Re: SSD 10399 — Clunies Ross Street, Prospect
Response to Blacktown City Council & Cumberland City Council

Further to your request we are pleased to provide our response to the civil items raised by Blacktown City Council in their information request letter dated 18 September 2020 and Cumberland City Council in their information request letter dated 16 September 2020 (refer enclosed)

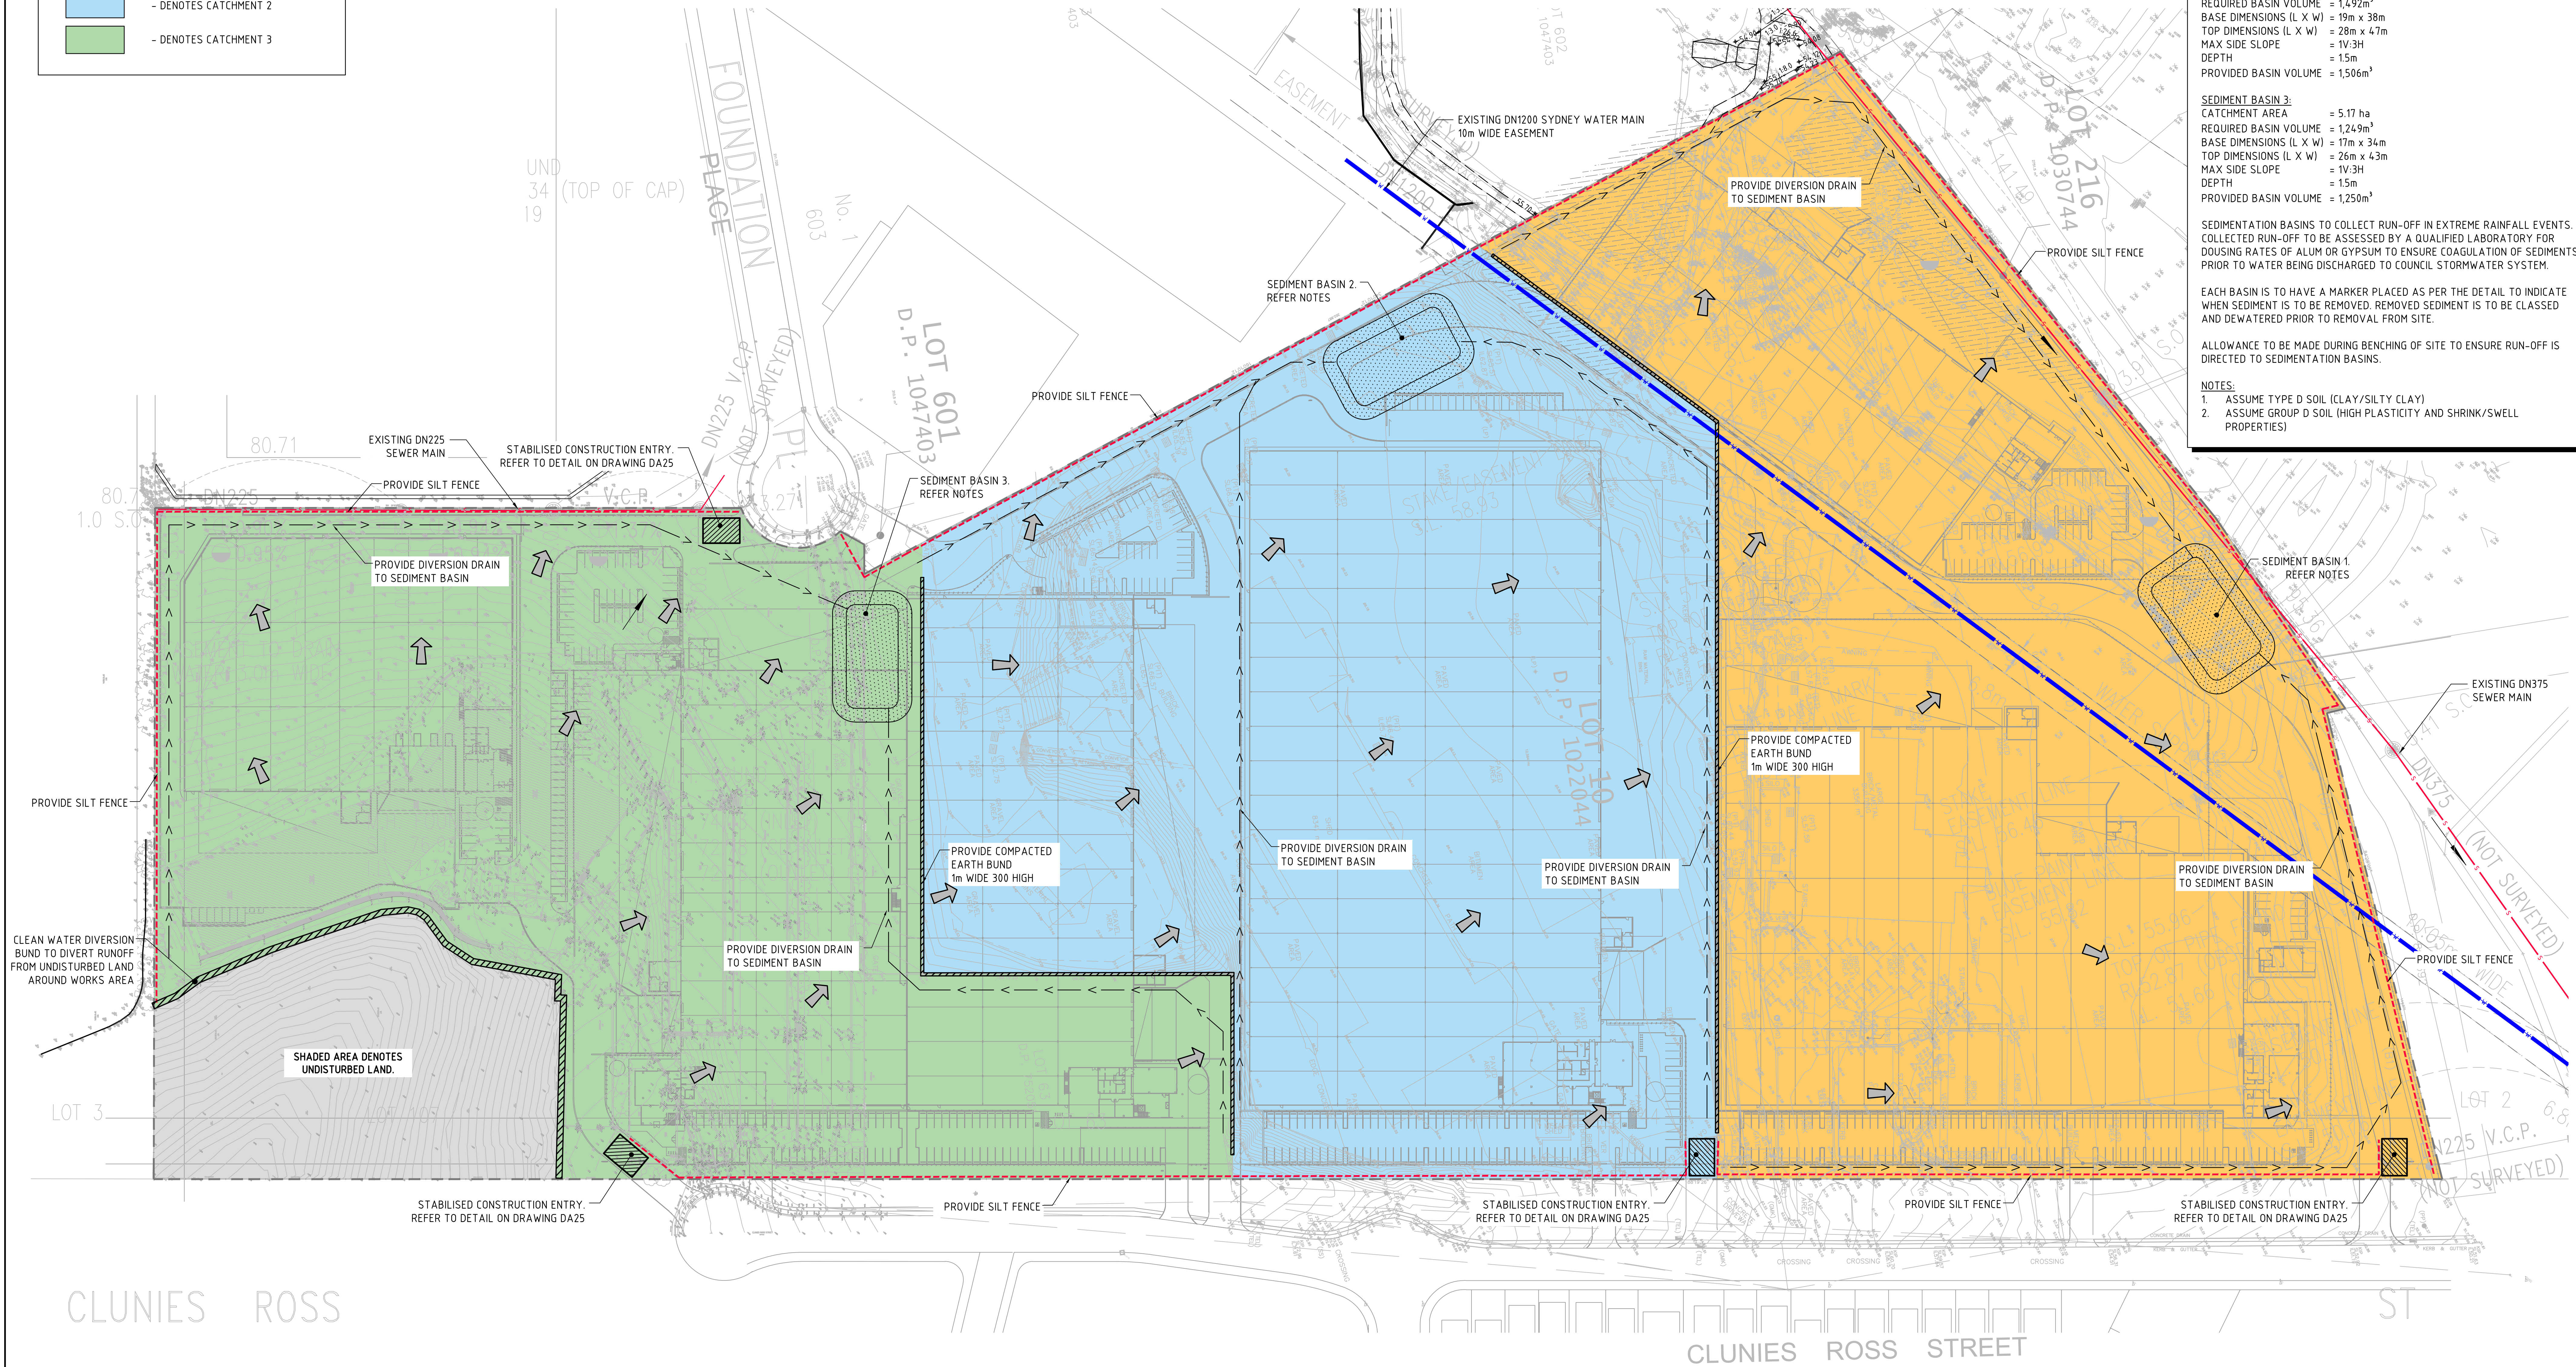
No.	Item and Response
<i>Sediment and Erosion Control</i>	
<i>Item 38)</i>	<i>A Sediment and Erosion Control Plan should be developed and implemented for the entirety of construction works on site. The Sediment and Erosion Control Plan should be designed to prevent the offsite migration of sediment from the proposed development.</i> <u>Response</u> Erosion and Sediment Control Plans have been included in the assessment submission. Refer to drawings Co13251.06-DA20 and DA25. Refer also Section 9 of the engineering report which includes a detailed draft stormwater management plan designed in accordance with Landcom Blue Book and Council Policy.

DRAWING TITLE: CONCEPT STORMWATER DRAINAGE PLAN SHEET 1

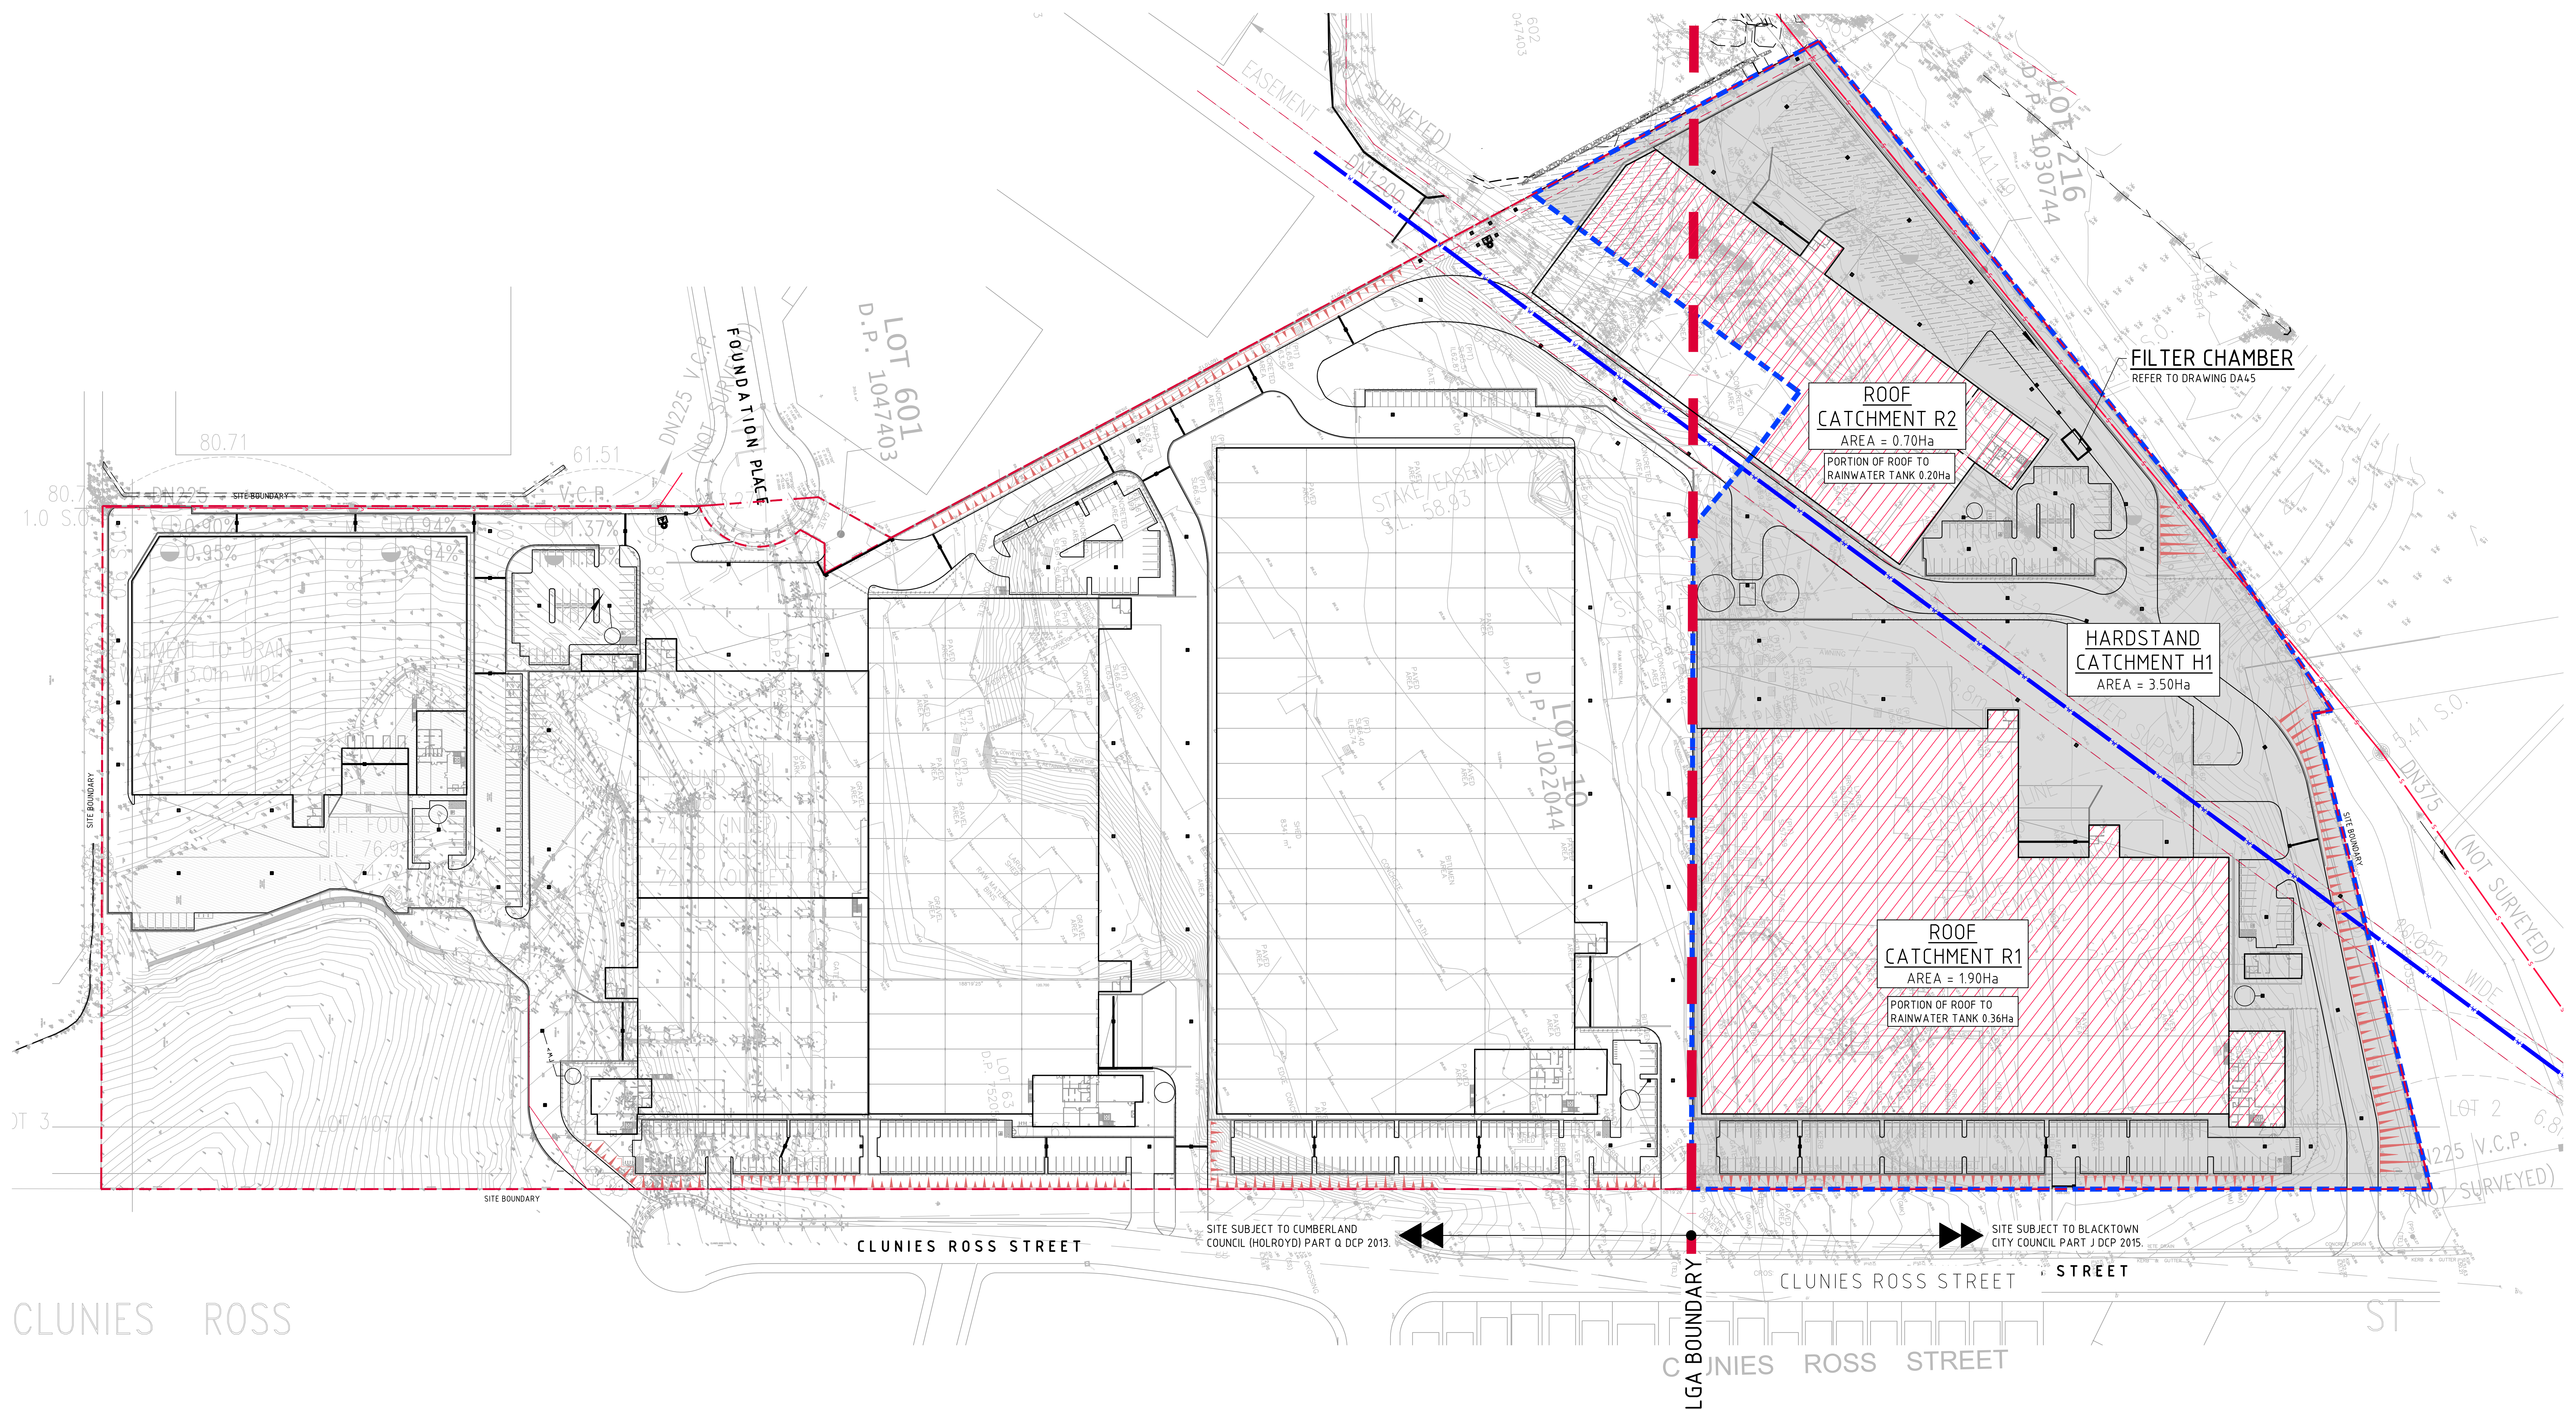
Item 19)	<i>Provide a MUSIC catchment plan that shows both the land use and the areas contributing to each specific device. To make this more understandable it may be easier in many cases to split these into two separate plans.</i> <u>Response</u> Overall catchments are shown on drawing Co13251.06-DA40. A separate MUSIC catchment drawing (Co13251.06-DA43) has been prepared for the BCC LGA zone.
Drains Modelling
